RIBBLE VALLEY BOROUGH COUNCIL

please ask for: GRAEME THORPE
direct line: 01200 414520
e-mail: graeme.thorpe@ribblevalley.gov.uk
my ref: 3/2012/0843/P
your ref: APP/T2350/A/12/2189415/NWF
date: 15 FEBRUARY 2013

RE – Appeal by Paddy Power Plc against the decision of Ribble Valley Borough Council to refuse planning permission for the change of use of 10 Market Place, Clitheroe from a bakery (Class A1) to Betting Shop (Class A2) including alterations to shop front. Includes erection of 3 x 900mm satellite dishes to roof of ground floor rear outrigger.

Front elevation - scale 1:50 @ A0

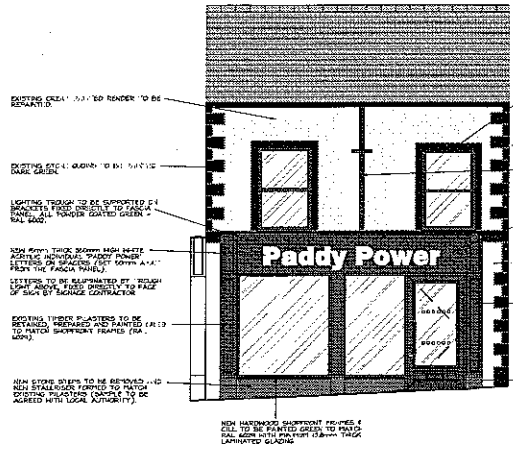
1. The applicant has put forward a change to the proposed shop front elevation of the scheme, drawing no. 2012/55/02 Revision D. Local Plan Policy ENV16 states that within conservation areas development will be strictly controlled to ensure that it reflects the character of the area in terms of scale, size, design and materials. This is a key consideration when assessing the proposed alterations to the shop frontage. When considering the proposed changes to the front elevation, whilst recessing part of a shop front can be considered traditional and provides interest, indeed there are examples of some doorways being set back within the Conservation Area, in this instance the proposed set back would still appear odd within an area of the streetscene more characterised by flush frontages.

3. Despite being an improvement on the scheme that was refused by the Local Planning Authority, the proposed replacement shop front is still considered to be harmful (i.e. does not preserve or enhance) to the property, a Building of Townscape Merit, as well as the wider Conservation Area, due to the frontage being recessed. The applicant has highlighted the requirements of Building Regulations as to the reason for the required recessed doorway that opens outward however given the plans indicate that a number of existing openings within the courtyard elevation are being blocked up, and could be used as fire escape routes without the need for a front door that opens out, it is the Council's view that approval of this element of the scheme would be contrary to guidance within paragraph 131 of the NPPF (does not conserve the heritage assets or make a positive contribution to local character or distinctiveness) and paragraph 134 (there are no public benefits of the proposal that would outweigh the harm).
